Two More Trains For Singleton

6 April 2011

Submission - Huntlee New Town Stage 1 Project Application

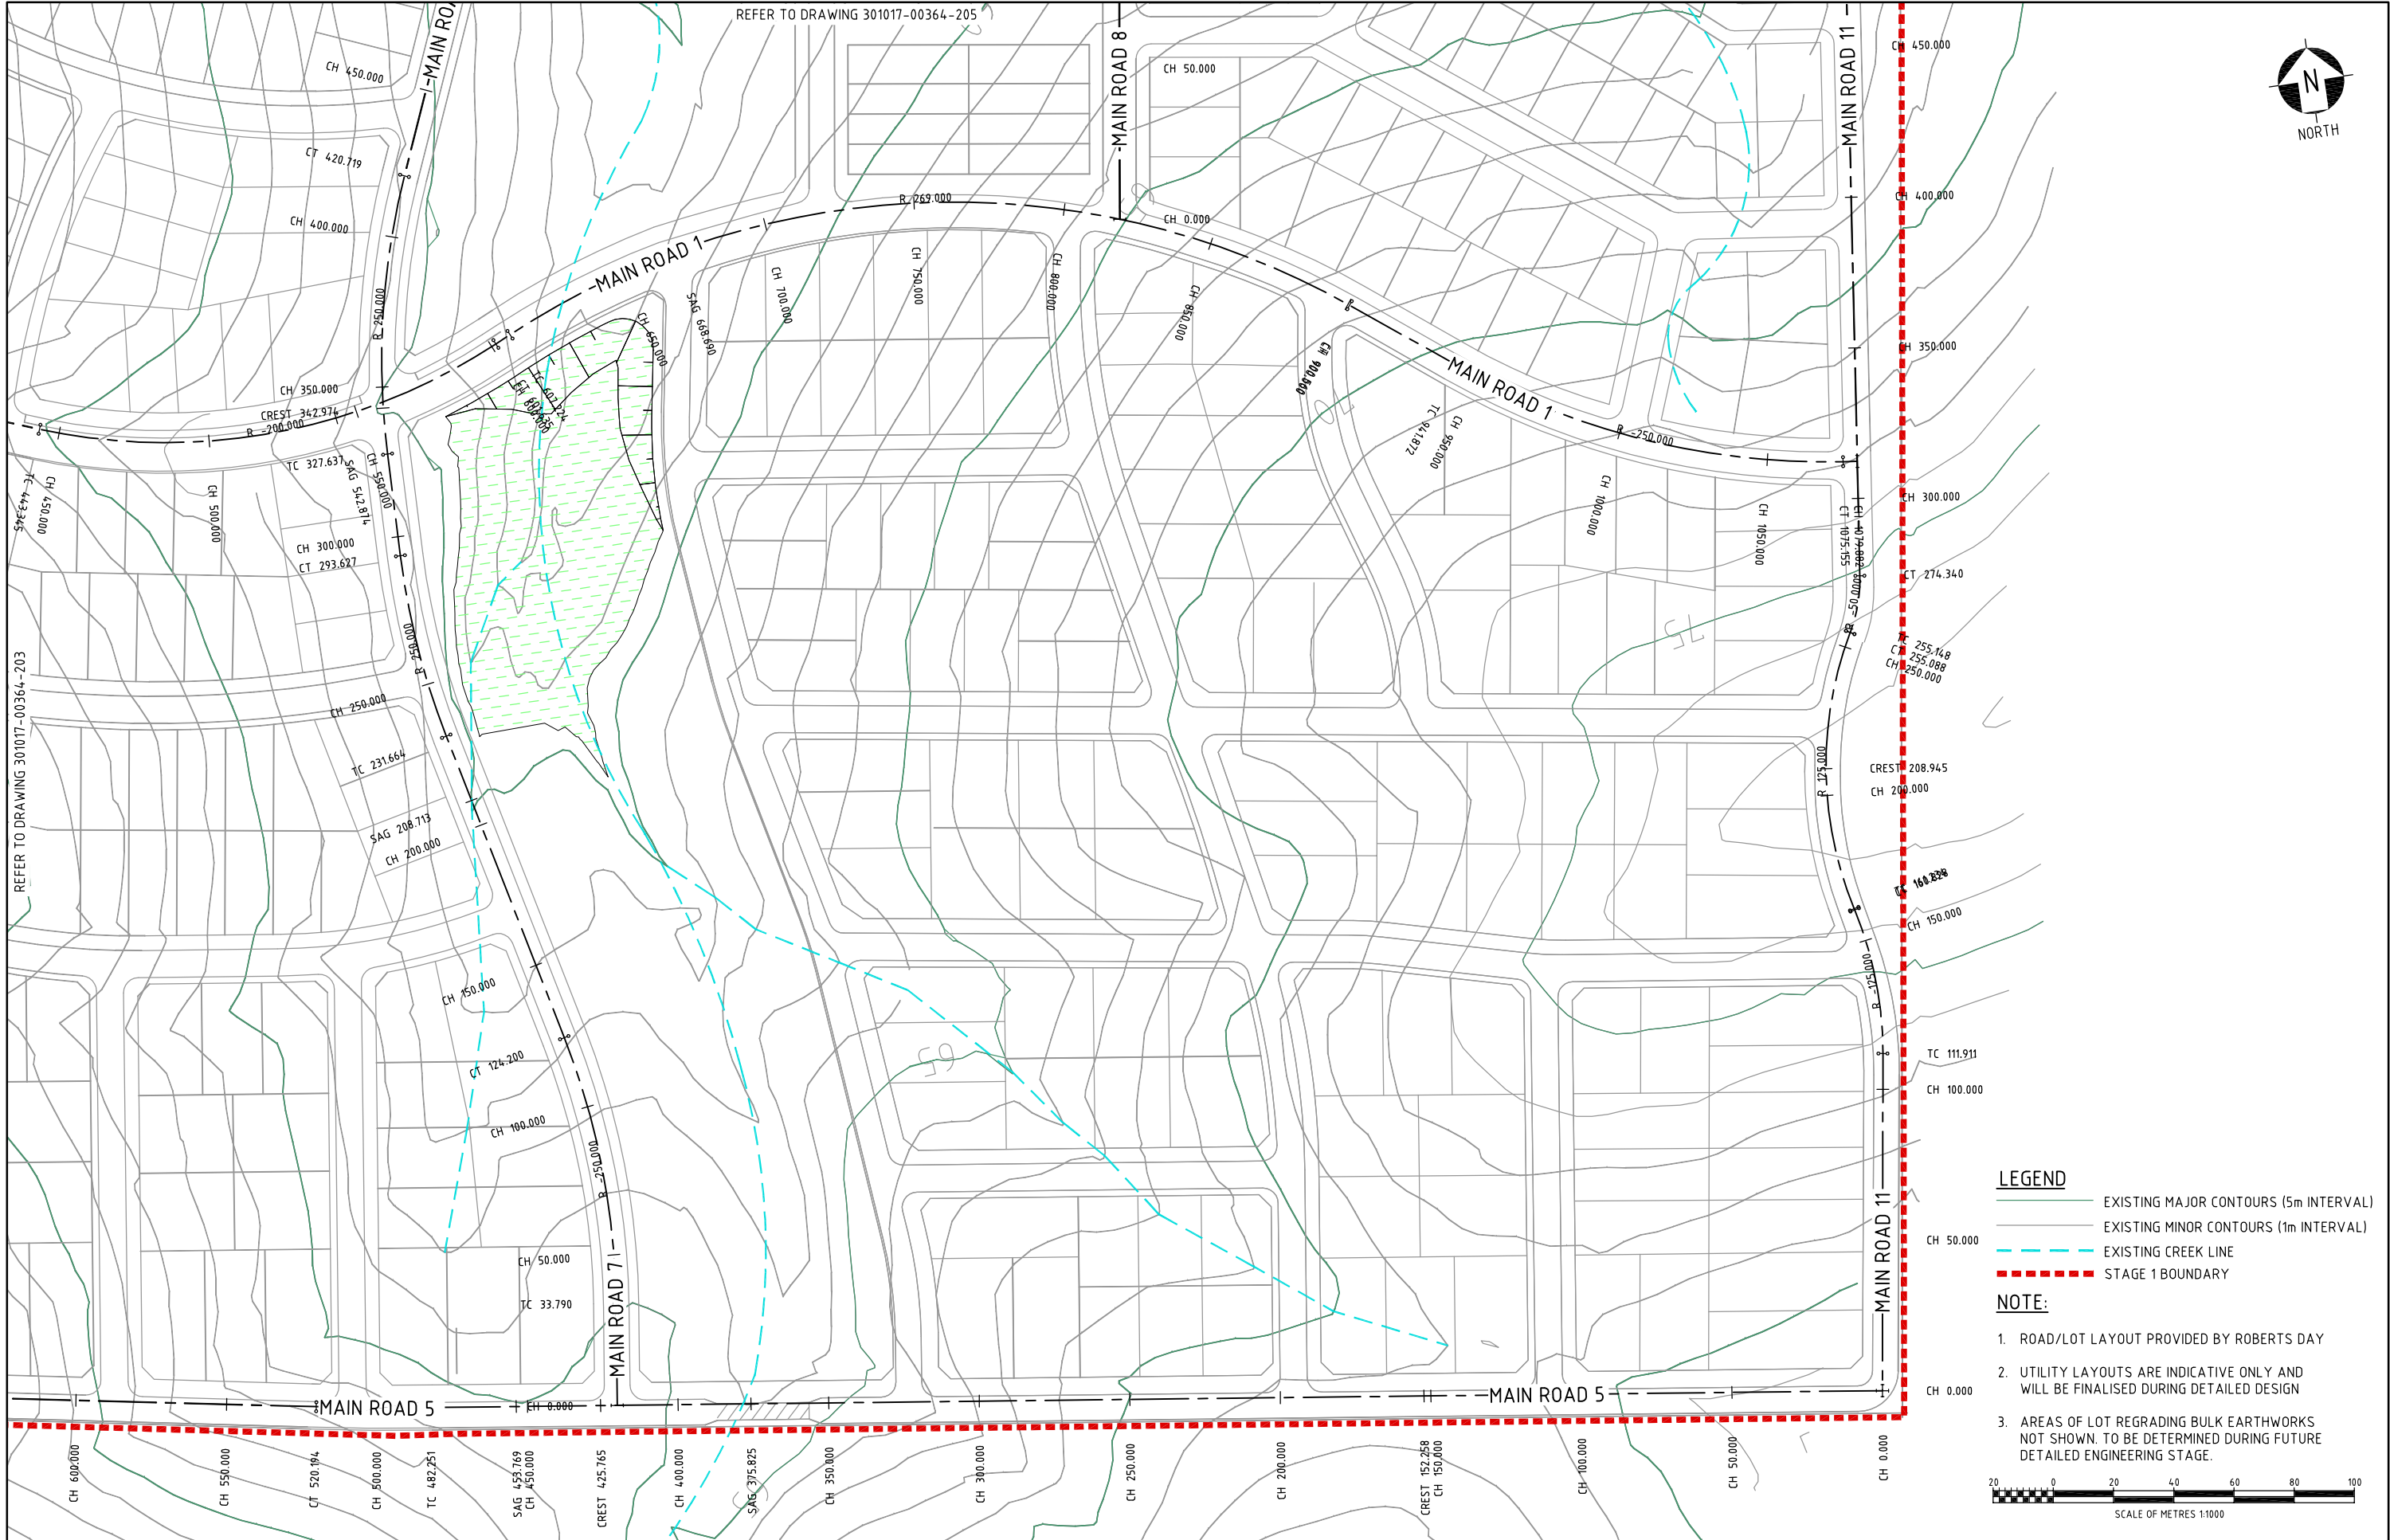
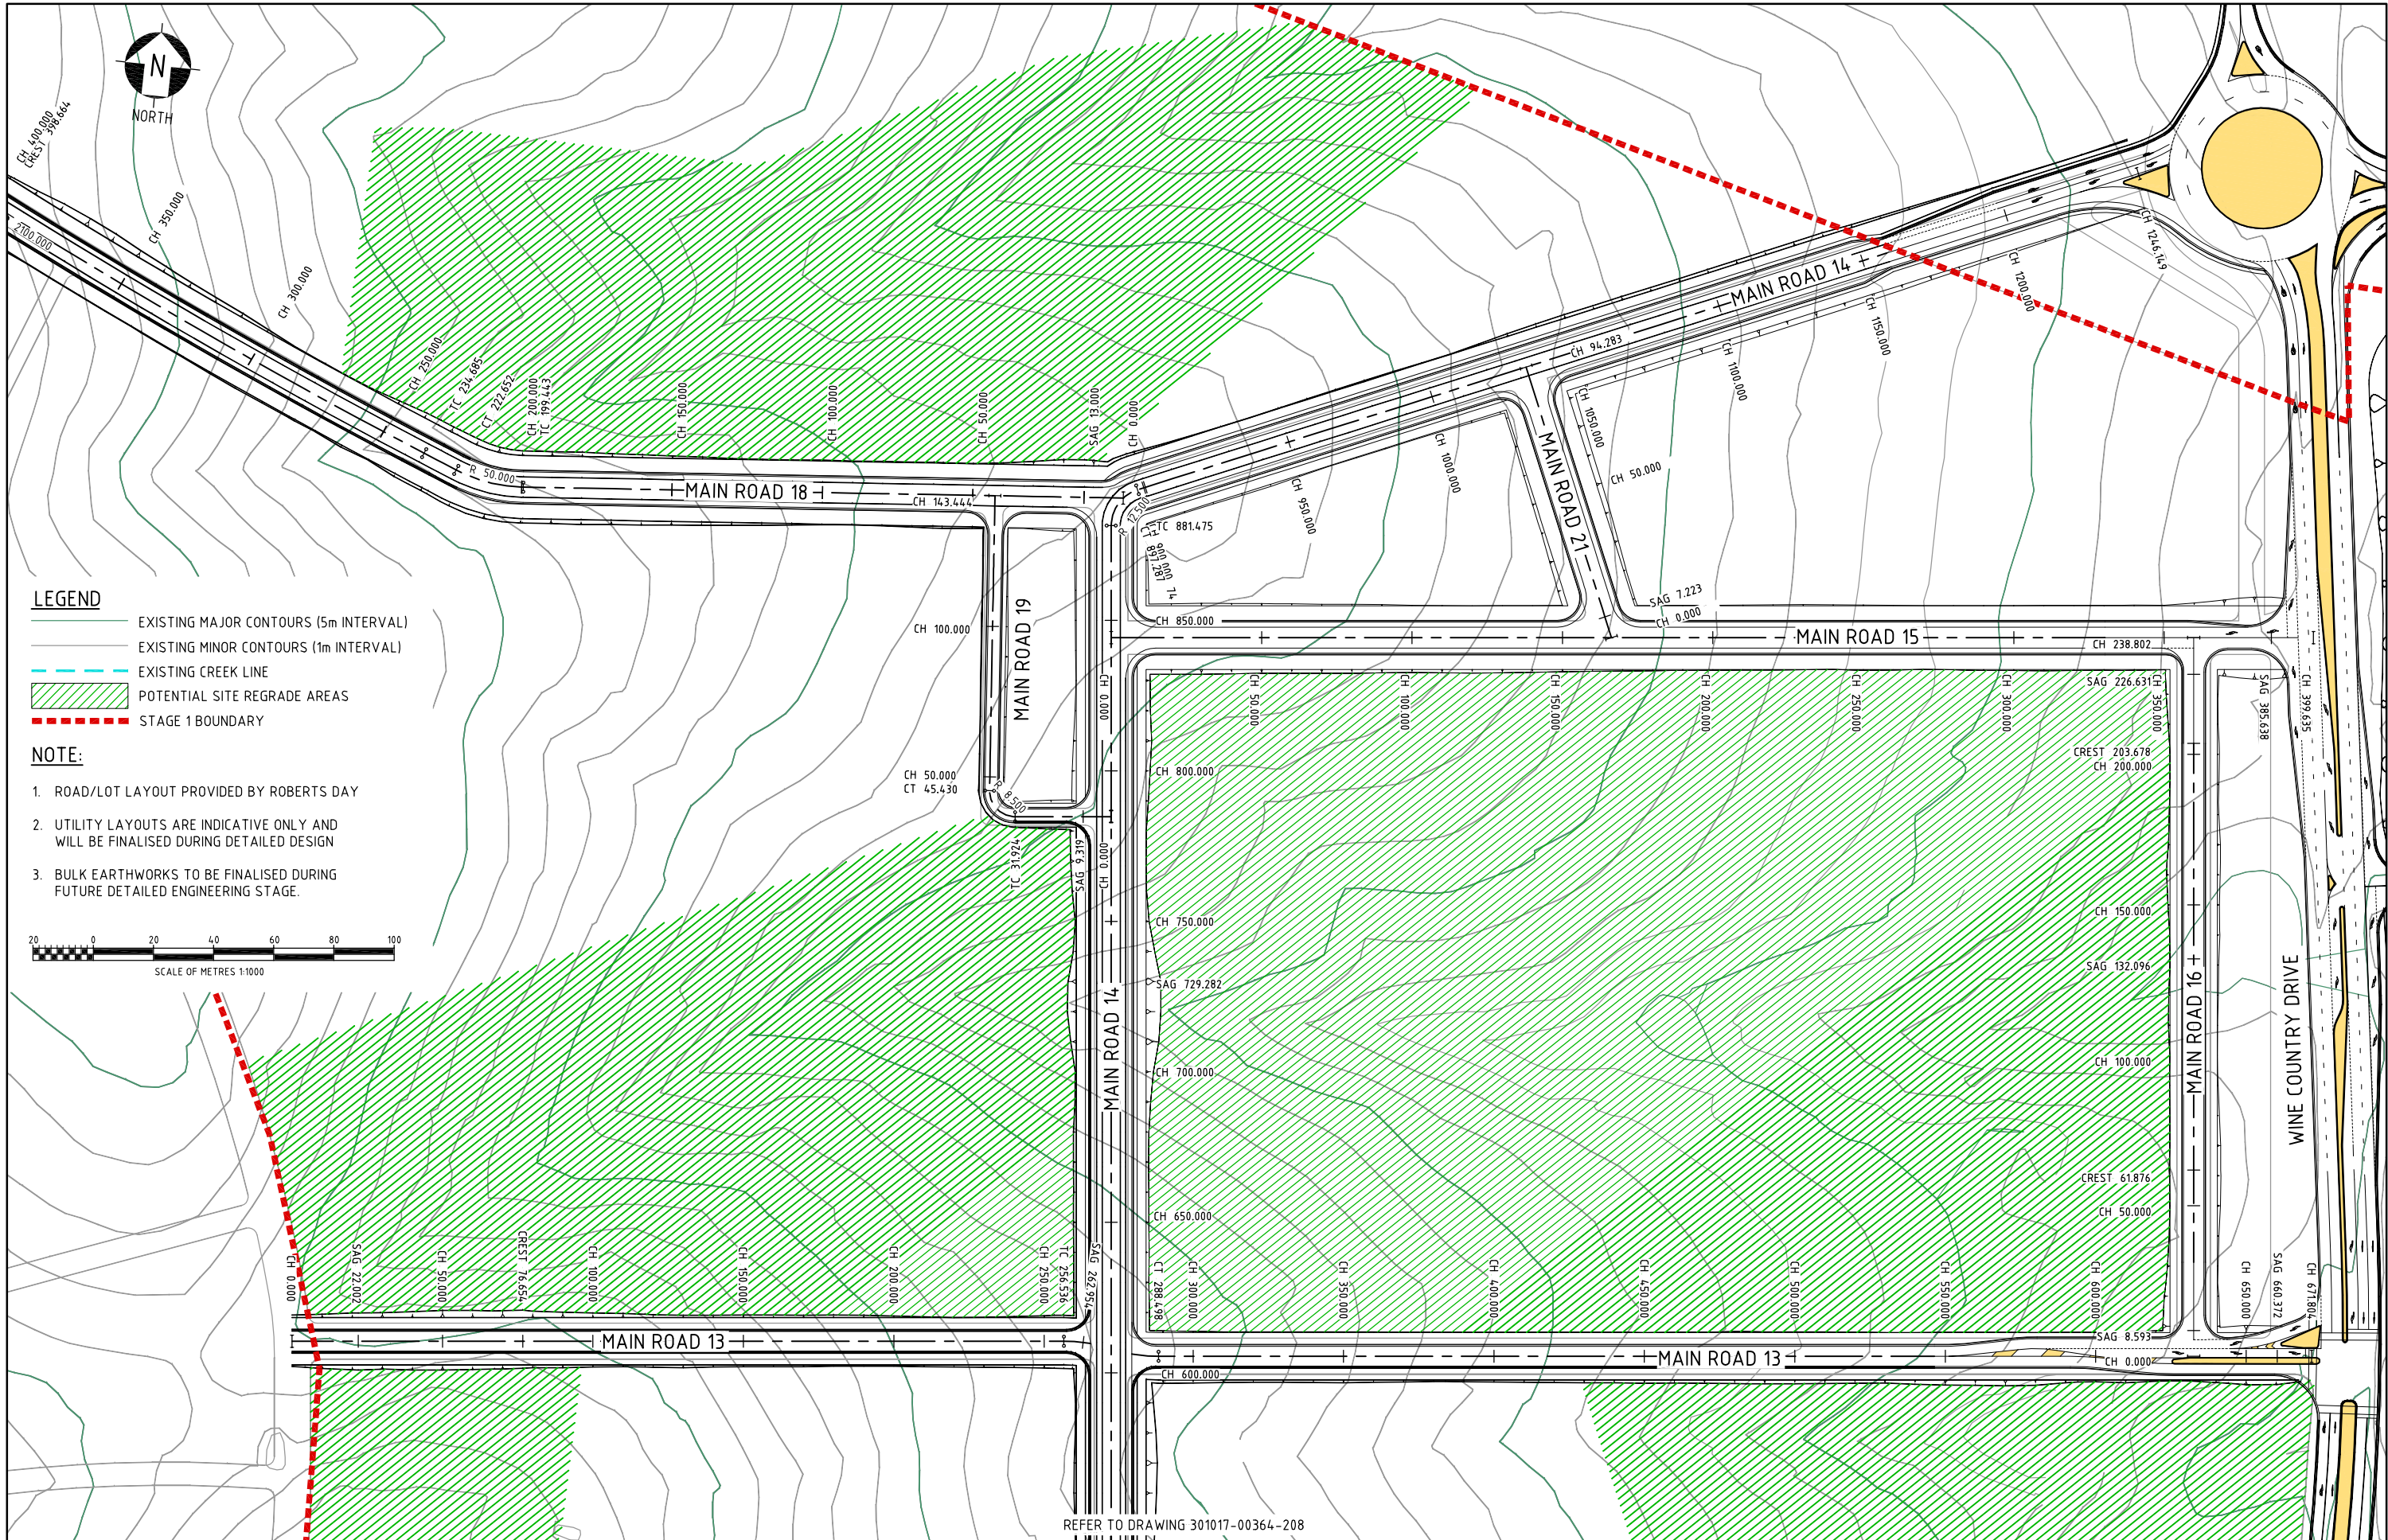
- 2 While the proposal has "no reliance on rail passenger transport", the layout should accommodate it. A railway station exists at Branxton within 500 metres of the proposed town centre area. The layout of the Huntlee proposal does not accommodate this, and the draft development control plan should include principles for how the development relates to the existing urban area of Branxton and accesses the railway station.
